DOC19/411951-20

**DA 401-11-2002-i MOD 11 - Use of Non-Standard Fuels – HiCal50 - Carbon Anode Material
Boral Cement Berrima**

I am writing in response to your email and attached supplemental Response to Submissions (RTS) dated 23 August 2019 to the Environment Protection Authority (EPA) seeking comment on the above development modification. This modification relates to the use of carbon anode material (HiCal50) in the Number 6 Cement Kiln at Boral Cement Limited's (Boral) Berrima plant.

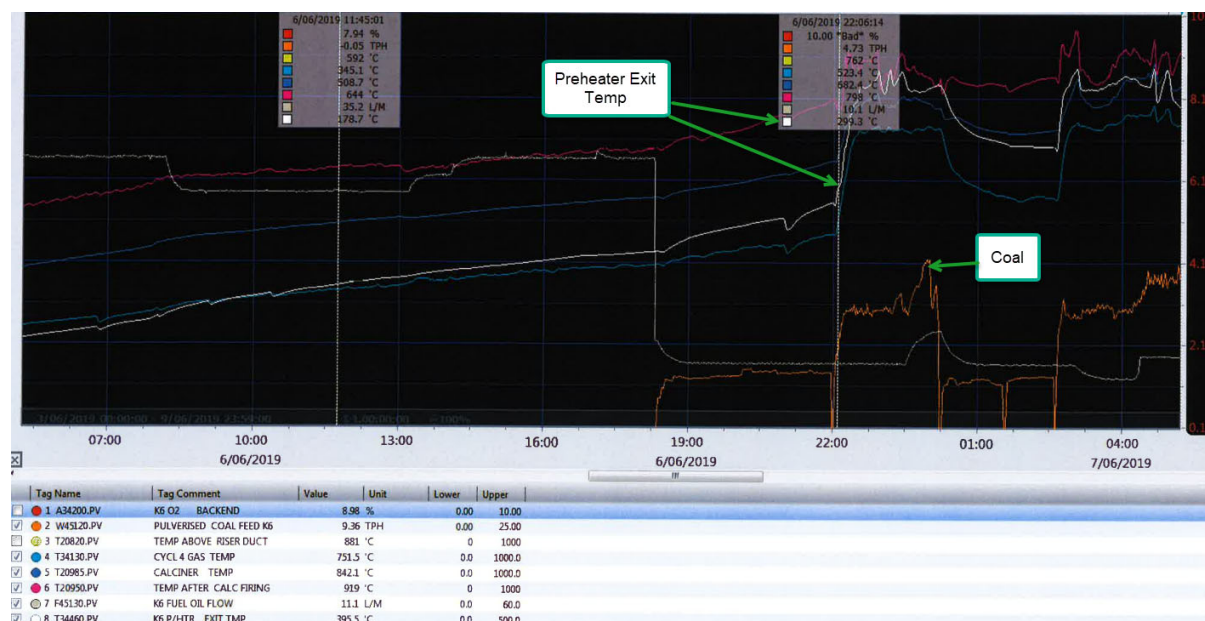
- With regards to process conditions (that is, temperature profiles) during start up, the previous additional information provided by Boral used an example of temperature profiles through the kiln during a historical cold start condition. The additional information states:

- Typically, the diesel rate gets up to 35 litres per minute (diesel is used during start-up prior to the introduction of coal). When the preheater temperature reaches 240 deg C, the diesel is reduced to approximately 10 litres per minute and the coal is introduced at a rate of 3.31 tonne per hour

- This rate is continued for approximately four hours. At this point the pre-heater exit temperature reaches 300 deg C and the coal usage is progressively increased towards > 12 tonne per hour via the kiln.

- Based on the example start-up regime, the coal/HiCal50 Blend at 96 per cent Coal and 4 per cent Hical50 would equate to 132 kilogram per hour of HiCal50 for four hours

- *Typically the diesel rate gets up to 35 litres per minute. In this example at about 18:00 on the 6/06/2019 when the preheater temperature reached 240°C the diesel is reduced to approximately 10L/min and the coal is introduced at a rate of 3.31 t/hr.*

- *This rate is continued for approximately 4 hours. At this point the preheater exit temperature reaches 300°C and the coal usage progressively increases towards >12t/hr via the kiln burner. See graph below. It is interesting to note in this example that there was a minor feed hiccup for coal but the residual temperature in the preheater stayed above the 300°C.*

- In EPA's response dated 1 August 2019 it was stated that "EPA has considered this aspect of the EPL and recommends the consent include a condition that no more than 135 kilogram per hour of HiCal50 can be processed when the outlet of the pre-heater strings is less than 300 deg C."

- In its submission dated 22 August, Boral advises that having a 135 kg/hr limit on HiCal50 during start up conditions will introduce an impracticable limiting factor for heat within the system, which will negatively impact the ability to start the kiln. It is not EPA's intent to recommend conditions that will impact the ability to start the kiln. The recommended rate was based on information previously presented by Boral (in the example above).
